From: Martyn White <Martyn.White@arun.gov.uk>
Sent: 14 December 2020 13:27
To: Planning.Responses <Planning.Responses@arun.gov.uk>
Cc: Simon Davis <Simon.Davis@arun.gov.uk>
Subject: Y/127/20/PL

Y/127/20/PL

Land at Main Road Yapton BN18 0EB

Construction of new access to serve residential development.

Drawing Title
**SECTION 278
ENABLING WORKS
AND WHITE LINING PLAN**

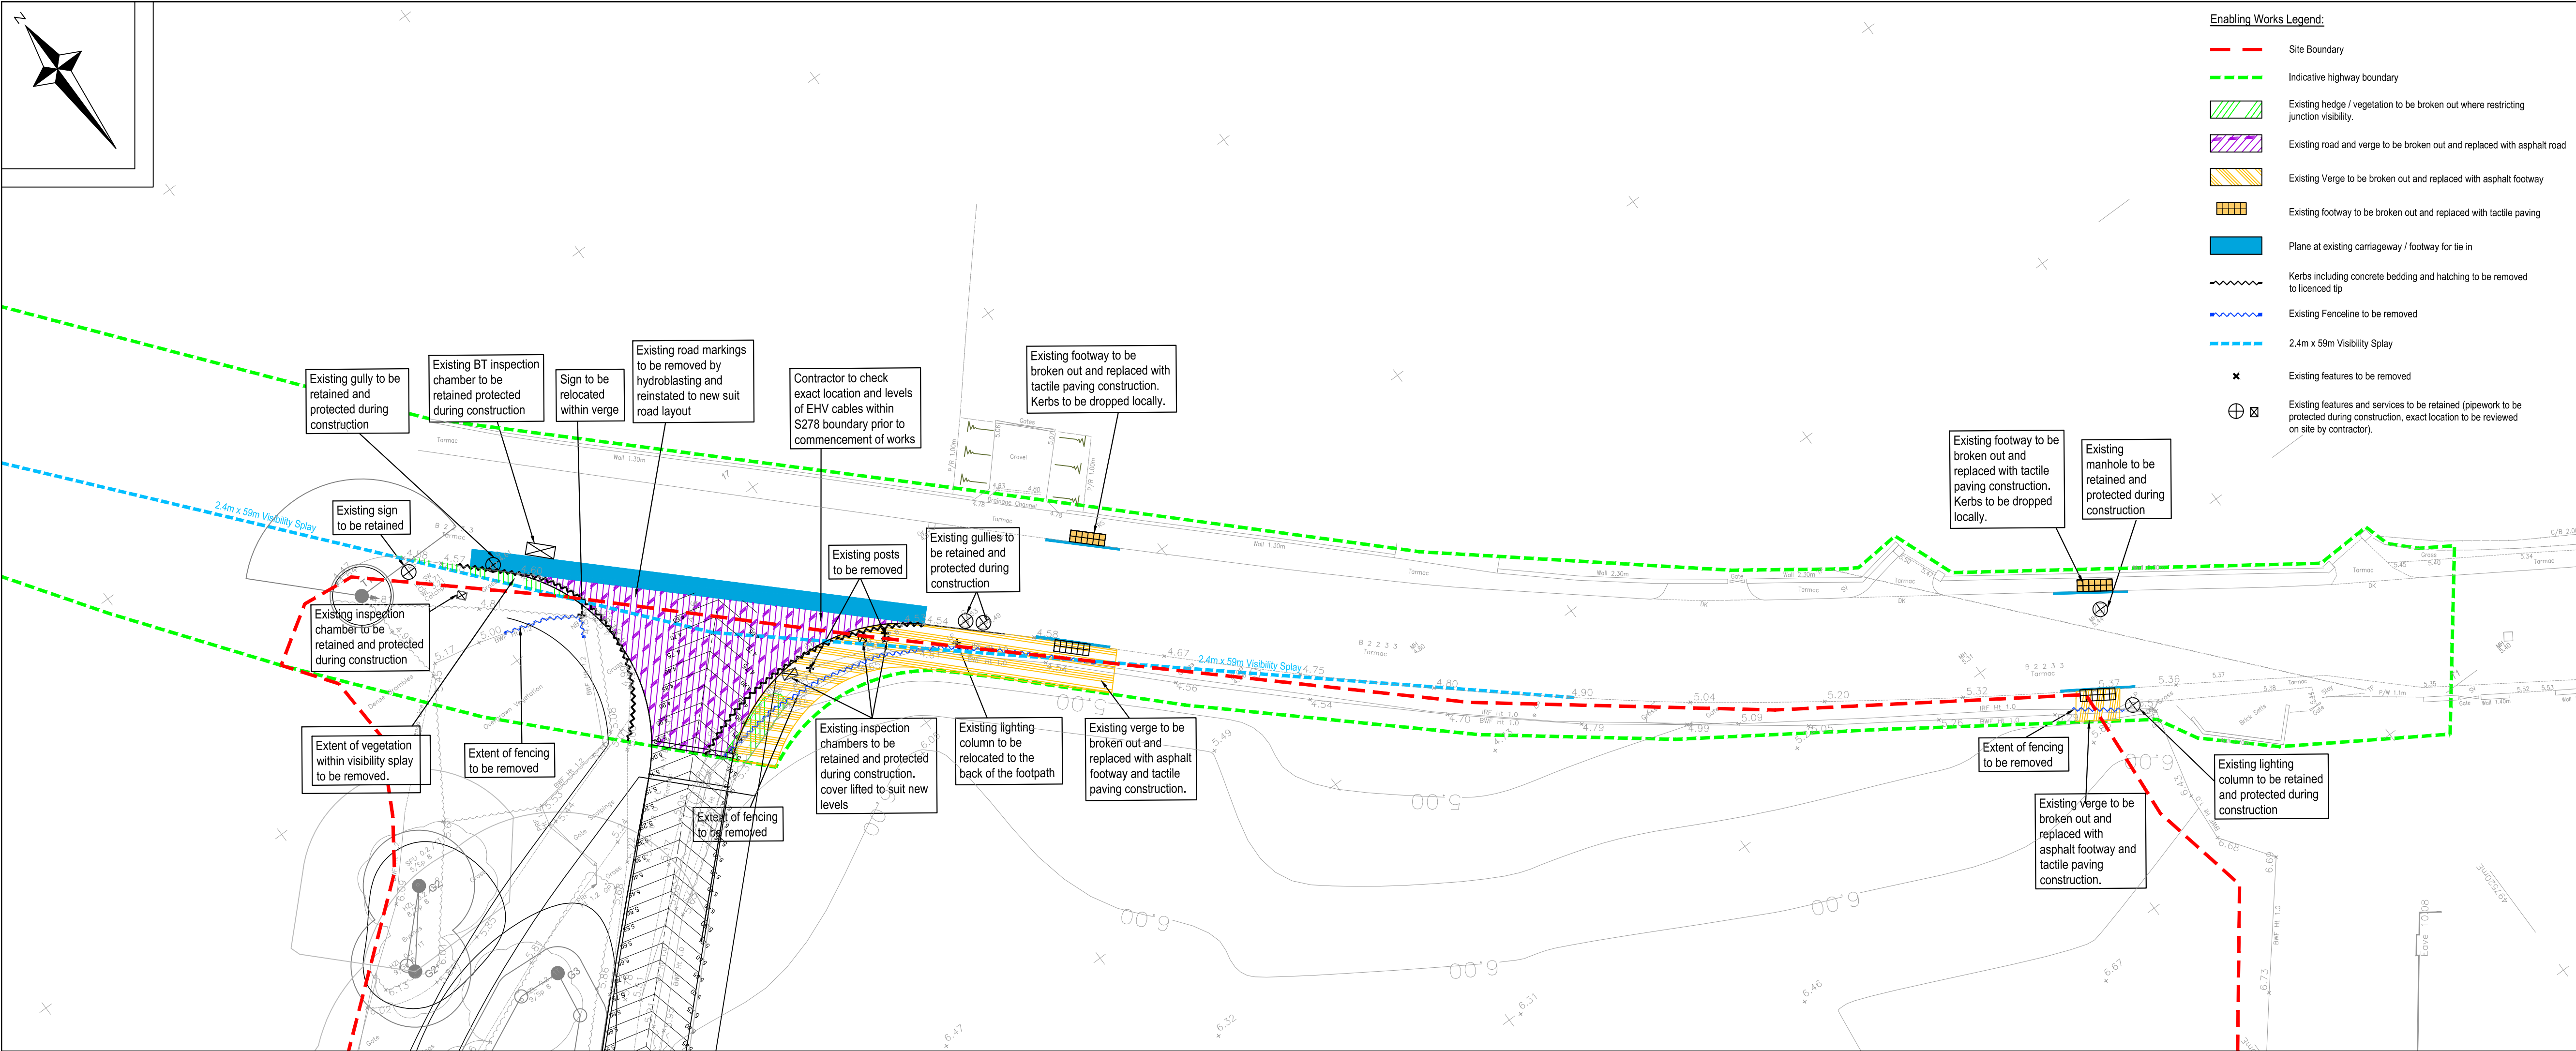
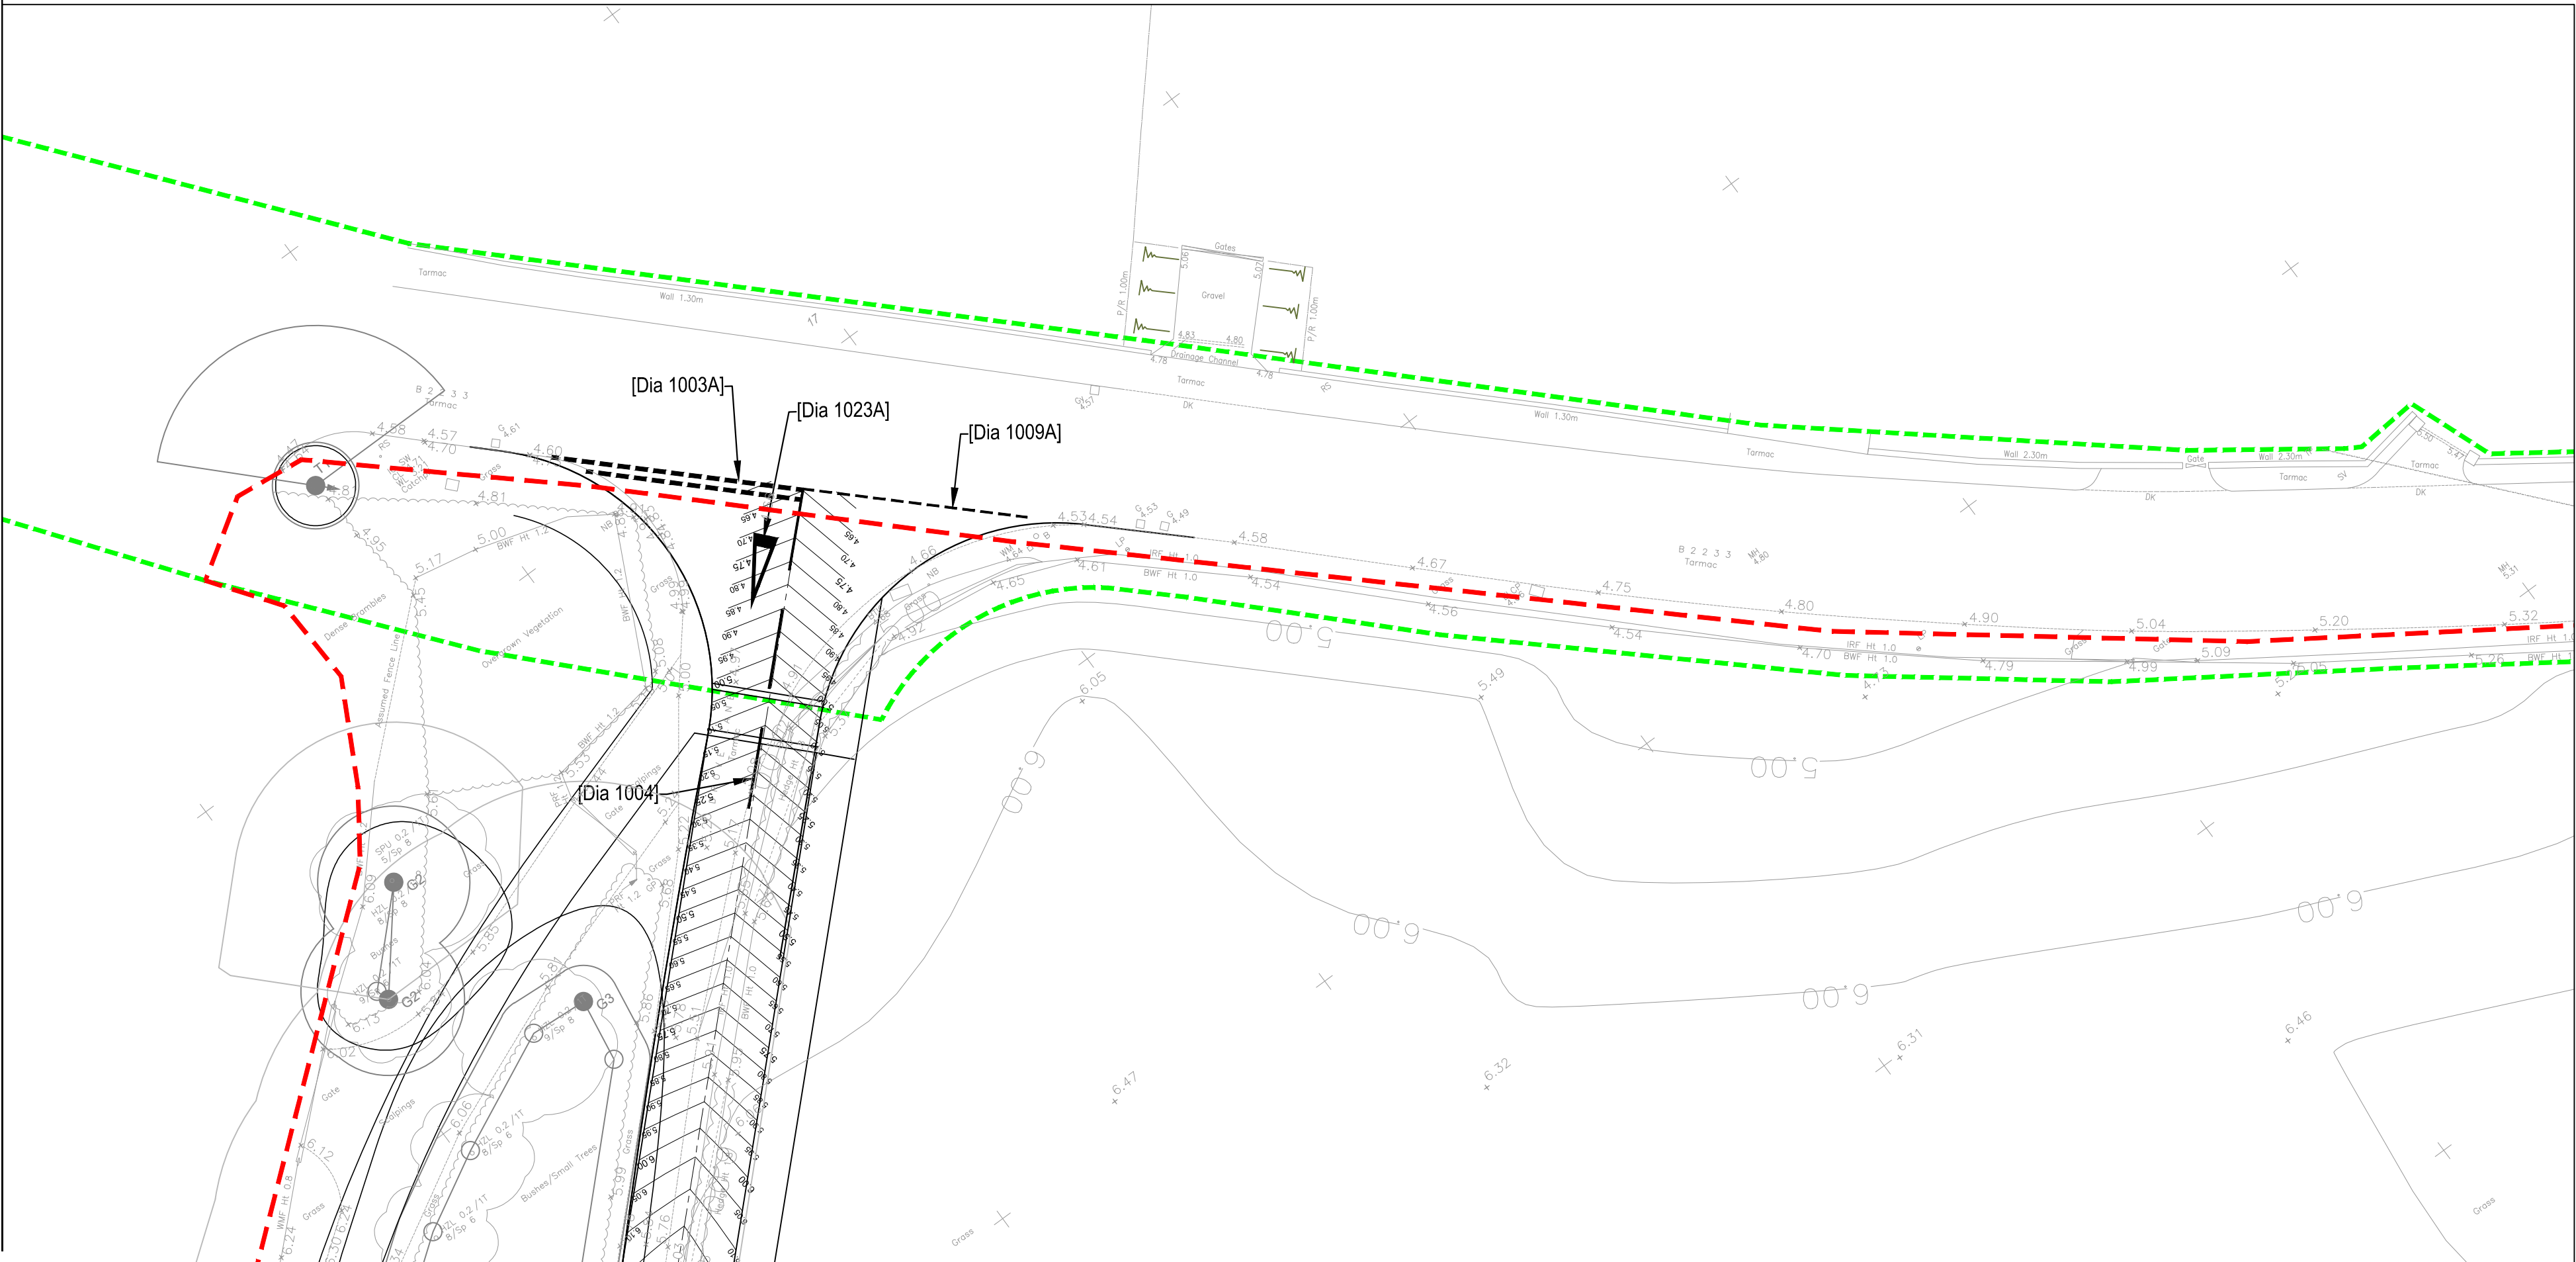
I have reviewed the plans supplied as part of this application and note that a large stretch of the existing estate fencing located at the point of the junction facing on to Main Road will be removed. It would appear that this is in order to facilitate the access arrangements and a proposed

pedestrian pavement. I also note that a smaller section to the east of the junction will also be removed to create a crossing point.

There does not appear to be any reference in the plans or the attached statement which identify that this fencing is to be reinstated next to the new pavement. This is disappointing and harmful as it is considered that this fencing forms part of the established character of the field and this part of the conservation area which also forms the entrance to the village. This approach would leave an isolated stretch of fencing which would no longer undertake its function of enclosing the small field, and would look out of place. It would also leave it vulnerable to being removed, which would cause further harm

It is also interesting to note that a neighbouring development propose to retain such features as part of their proposals, and it is not clear why the same approach cannot be followed here. The proposal is therefore considered to be harmful to the character of the area.
